Consultee Comments for Planning Application 2024/93366

Application Number: 2024/93366

Address: former Britvic premises, Willow Lane, Birkby, Huddersfield, HD1 5EB

Proposal: Change of use from B2 to mixed used site consisting of B2 (General Industry), B8 (Storage and distribution), class E (offices), Class F (Learning and non-residential institutions), exhibition / venue space.

BASEMENT

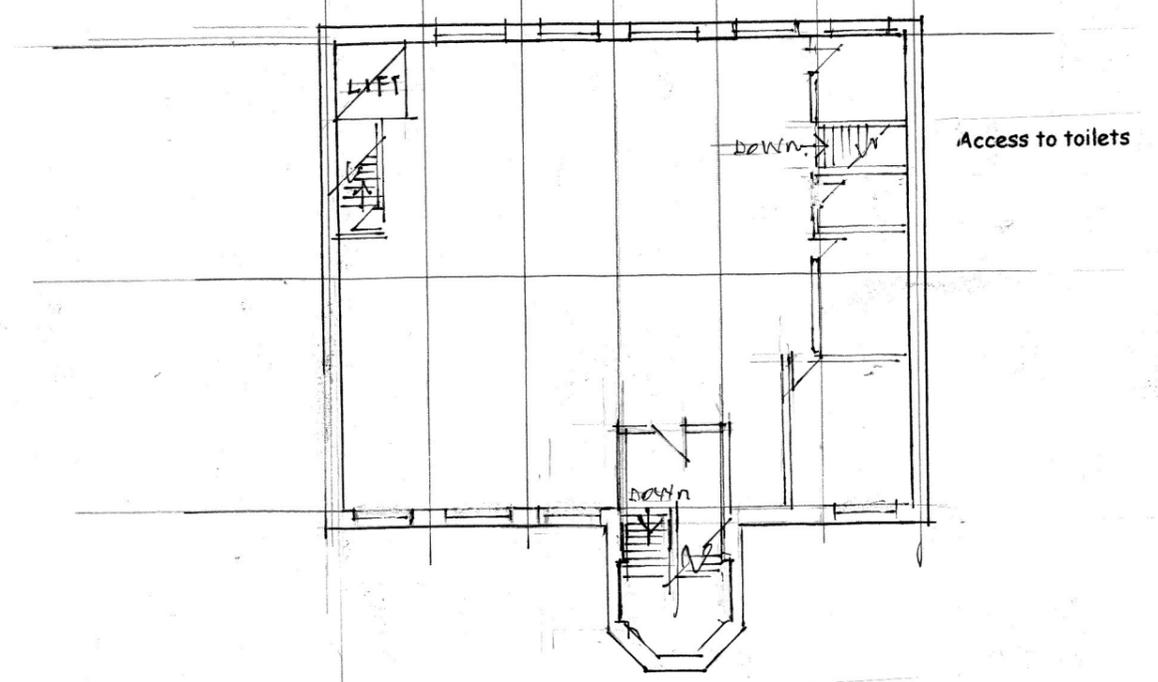
Basement area is to be utilised as recording studios and a live music venue, with additional venue hire space on the second floor. More information is required in relation to the music and hire venues' capacity, opening hours and whether the sale of liquor is intended; depending on the information provided, the application may need to be referred to CT Security Advisors as part of assessment into crowded places and publicly accessible locations.
